Re Planning Application: 19/01746/OUT Land Adj To Promised Land Farm Wendlebury Road, Chesterton

In my capacity as Cycling Champion for Oxfordshire County Council, I am writing to raise my concerns regarding the inadequate provision of active travel network connectivity with regard to the above outline planning application.

## PROPOSED SURFACING PLAN

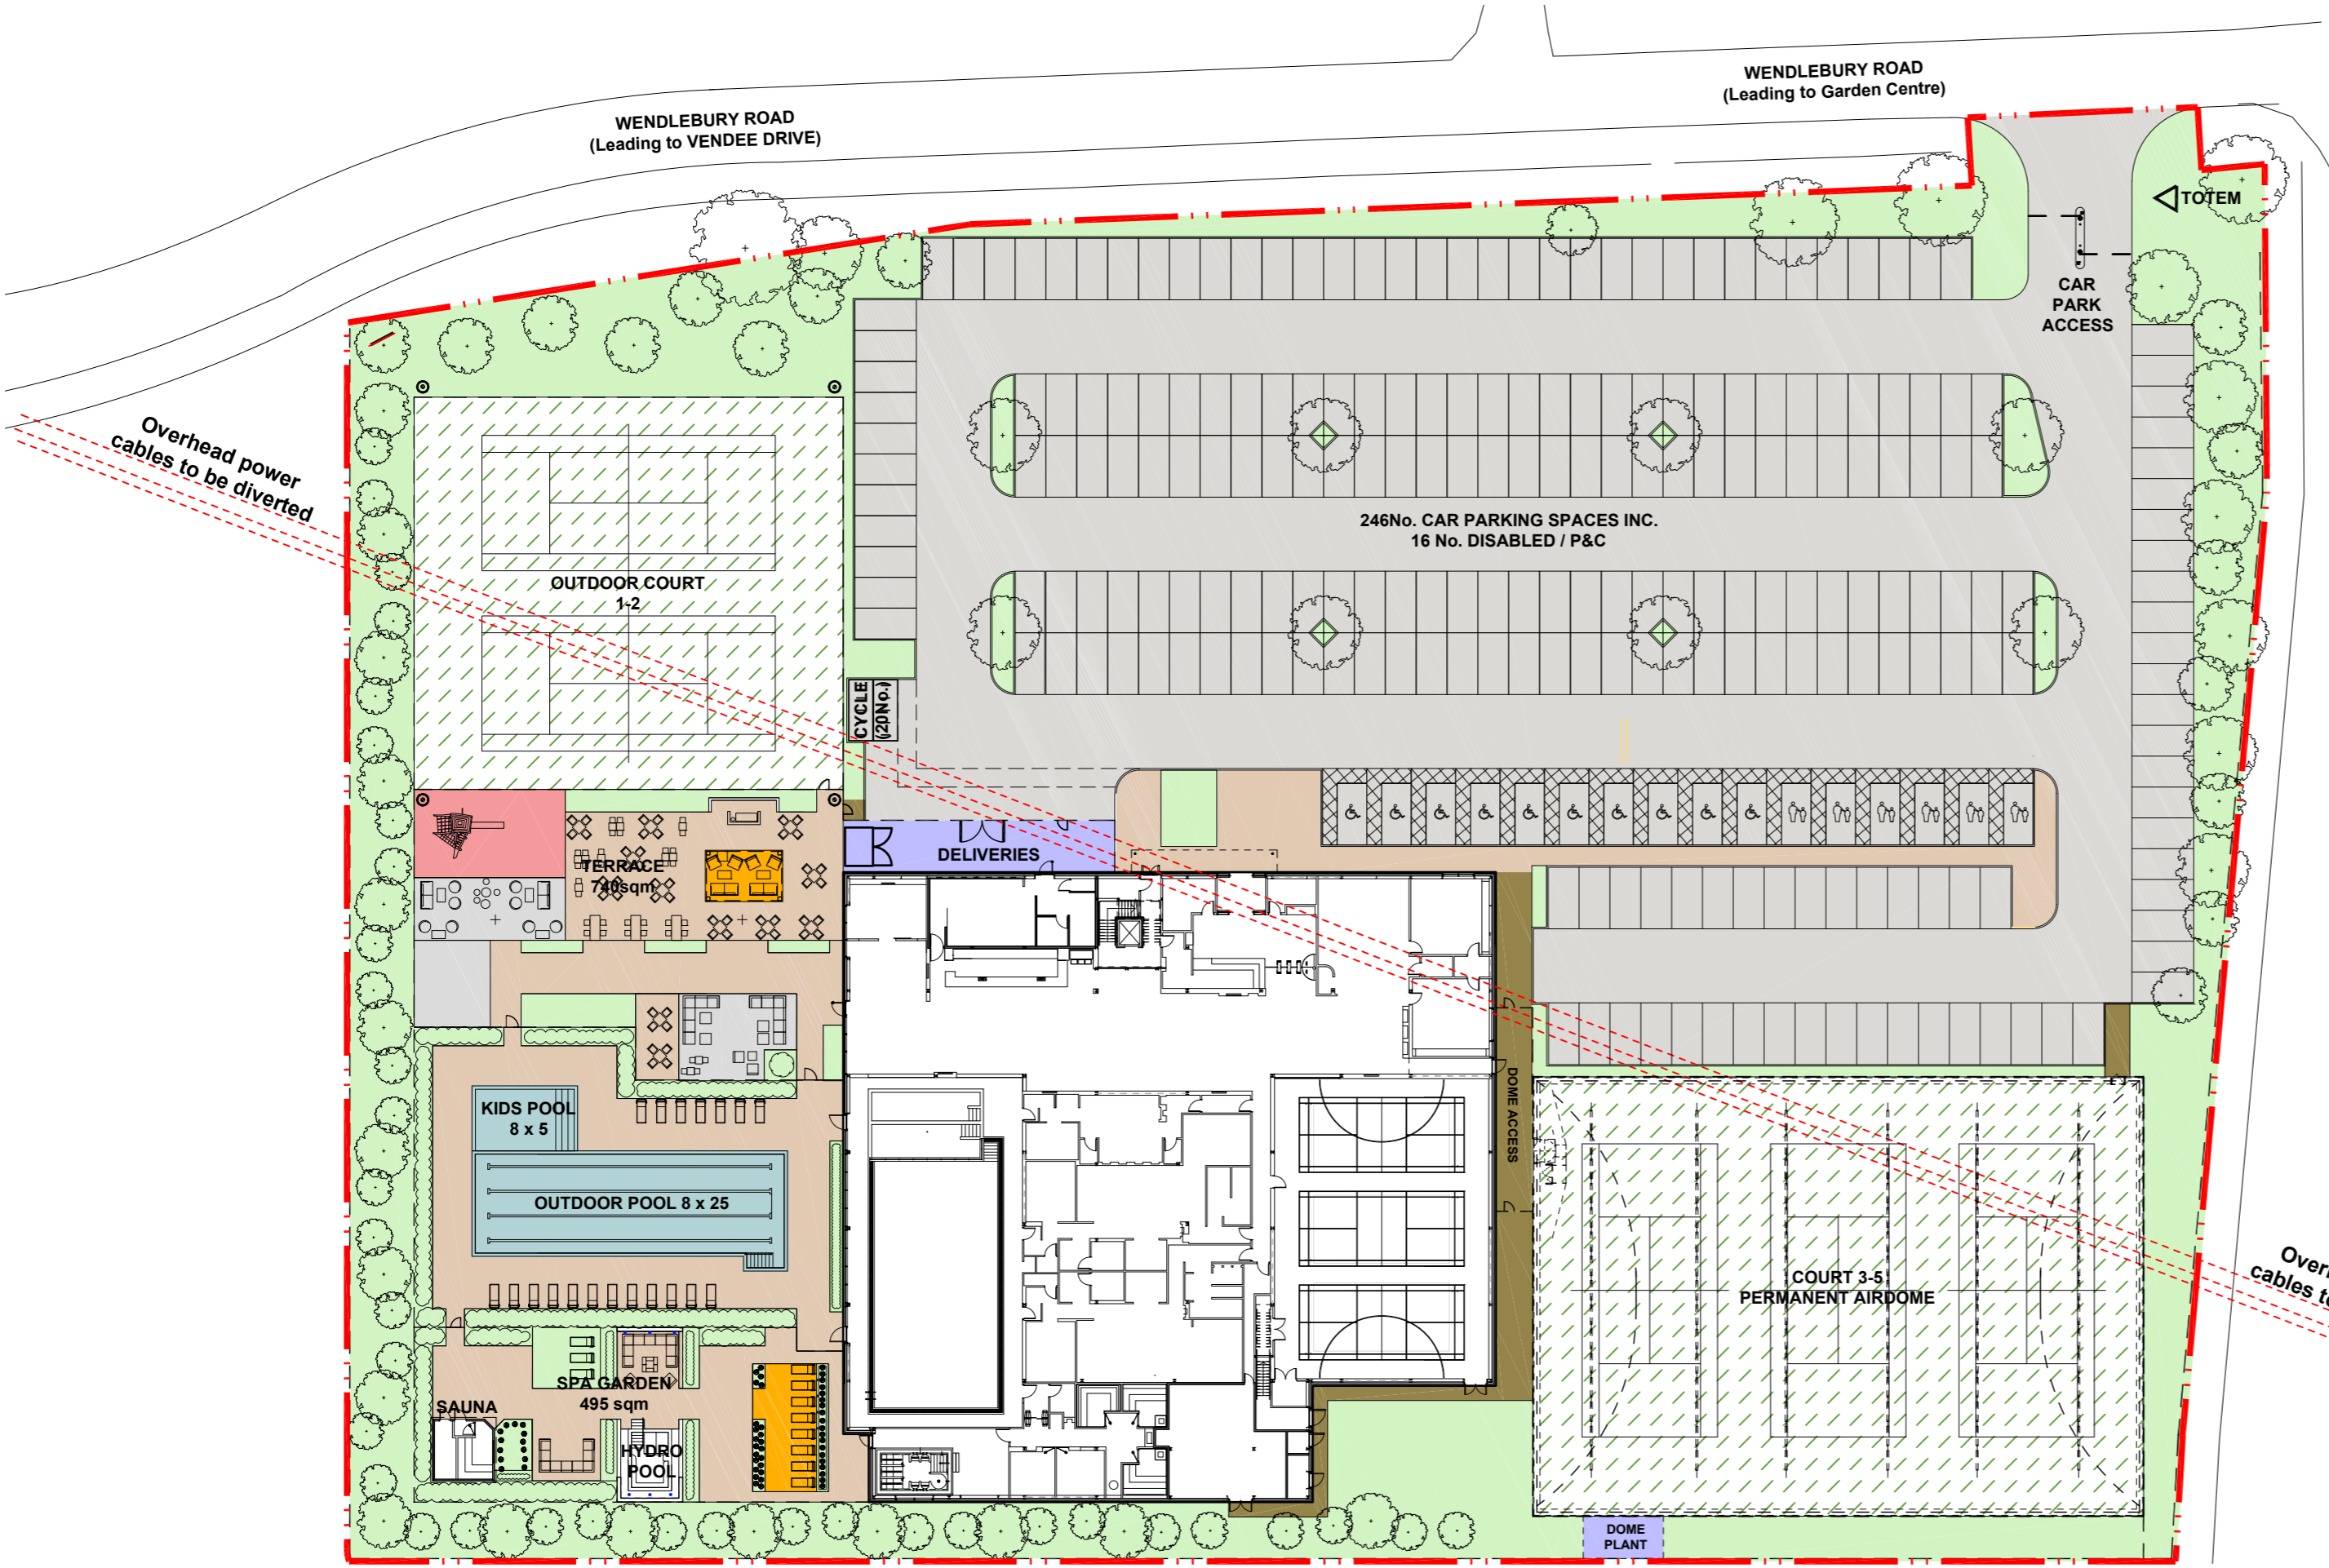
- 4) The proposals indicate 250 car parking spaces and only 20 cycle spaces, this shows insufficient ambition regarding active travel and is likely to contravene the OCC guidelines of 1 space per 150m². It is also not evident if these are enclosed, protected lockable facilities or open air spaces.
